Appeal Decision

Appeal Ref: APP/R5510/W/24/3350018

84 East Road, Hillingdon, West Drayton UB7 9HA

- The appeal is made under section 78 of the Town and Country Planning Act 1990 (as amended) against a refusal to grant planning permission.
- The appeal is made by Mr J Singh against the decision of the Council of the London Borough of Hillingdon.
- The application Ref is 31005/APP/2024/1086.
- The development proposed is construction of two storey attached dwelling on land at no. 84 East Road.

Drawing Title: Proposed Site Plan **Client:** OSN Group **Date:** 09/07/2024 **Drawn By:** SY
Status: Plans Proposed **Scale:** 1:200@A3 **Project No:** 1031 **Drawing No:** 1031-11_Rev10 **Rev:** 10

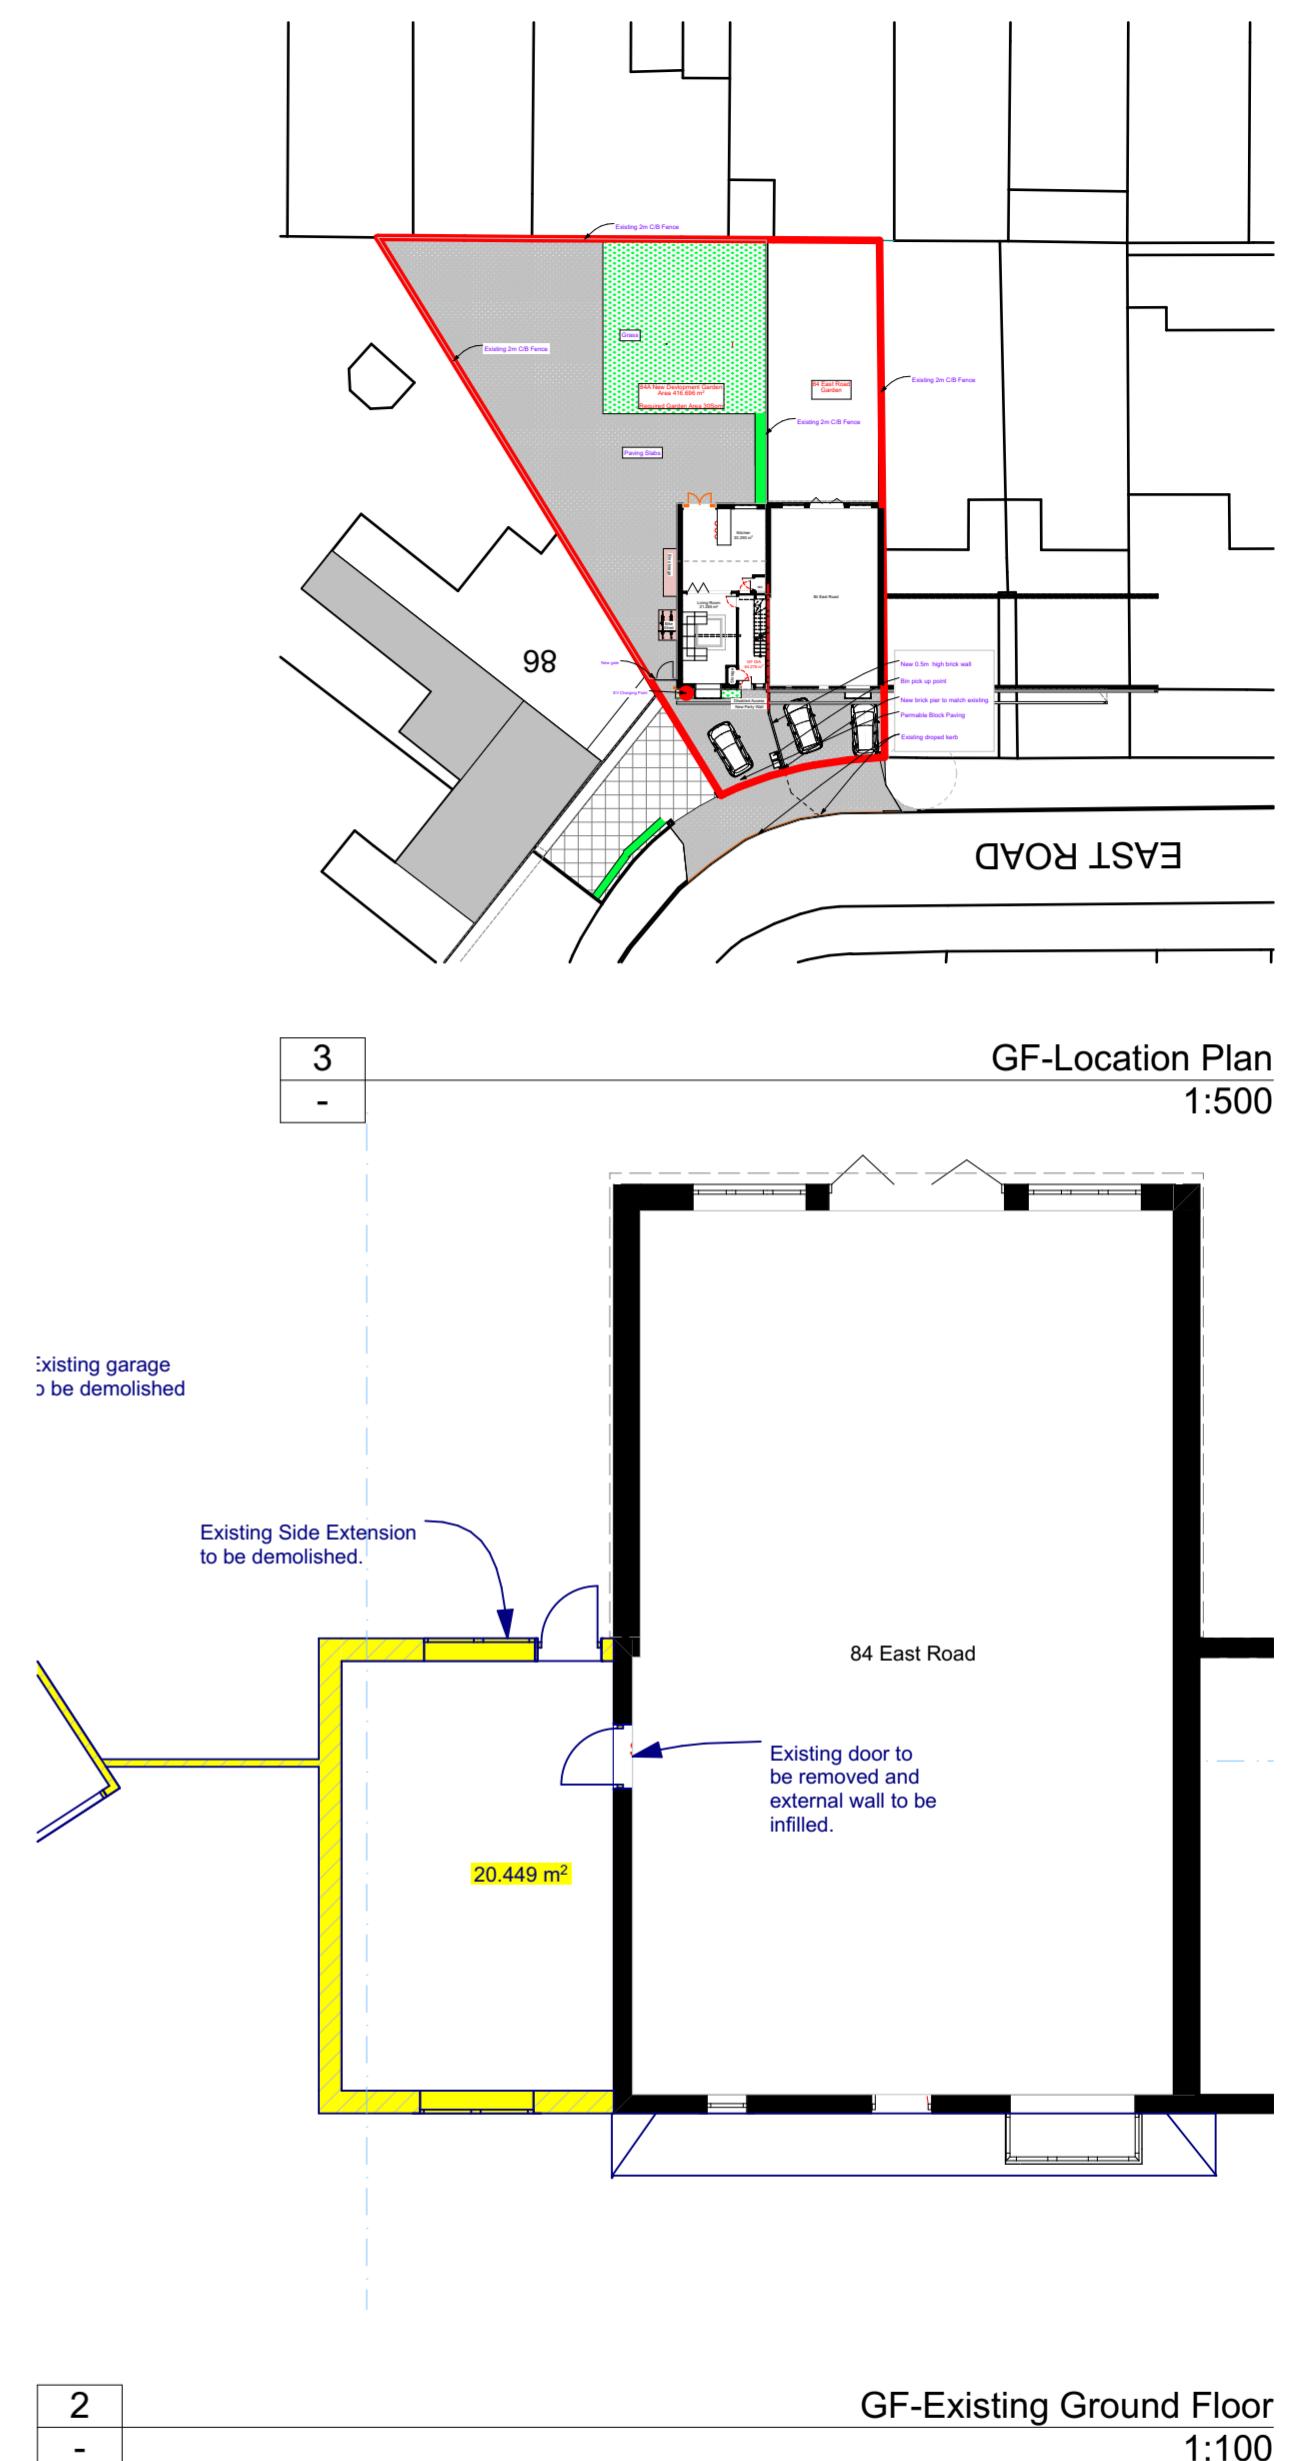
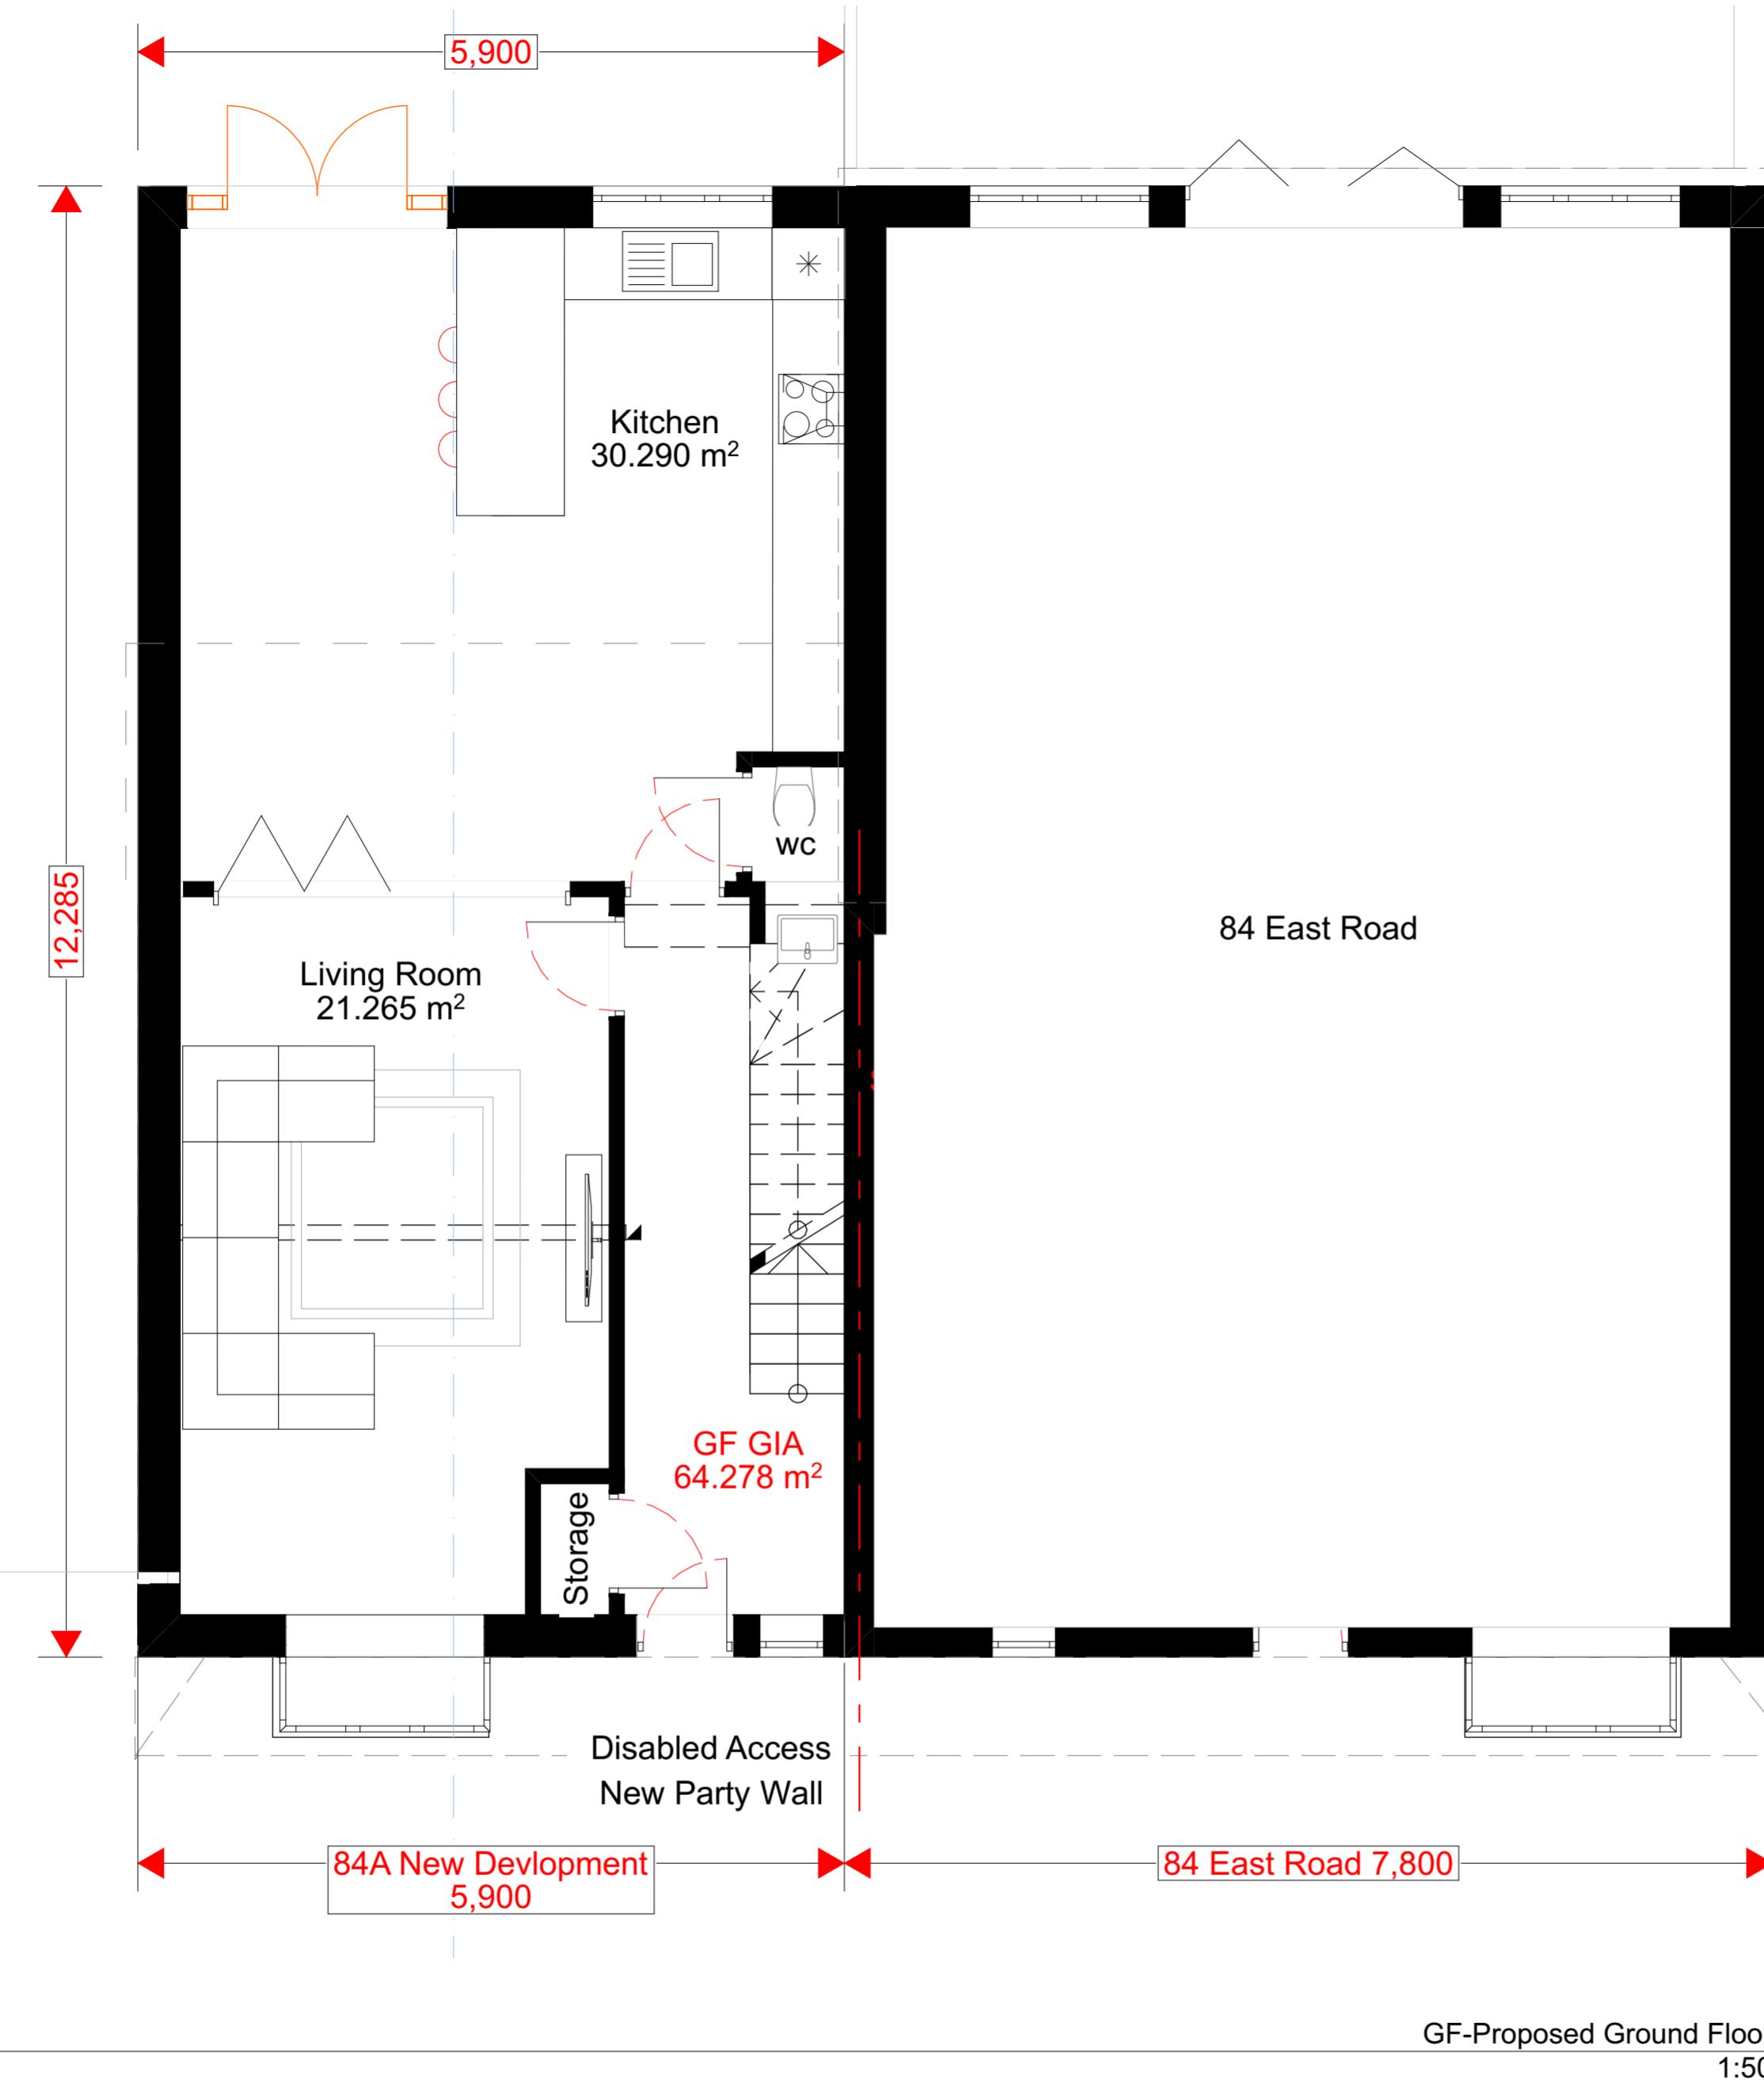
4. The proposed dwelling would be attached to No 84 and occupy almost the entirety of the remaining width of the plot, leaving a small gap between the neighbouring property which would be used as the access to the rear garden of the proposed dwelling.

5. The proposal would match the building line and height of the existing dwelling and would therefore appear as an obvious addition to the row of terraced houses. The proposal would close a substantial portion of the existing spacious gap and result in a property that would appear cramped at the end of the existing row of terraced properties, particularly due to the very small gap that would barely be visible at ground floor level due the proposals proximity to the existing extension at No 86.
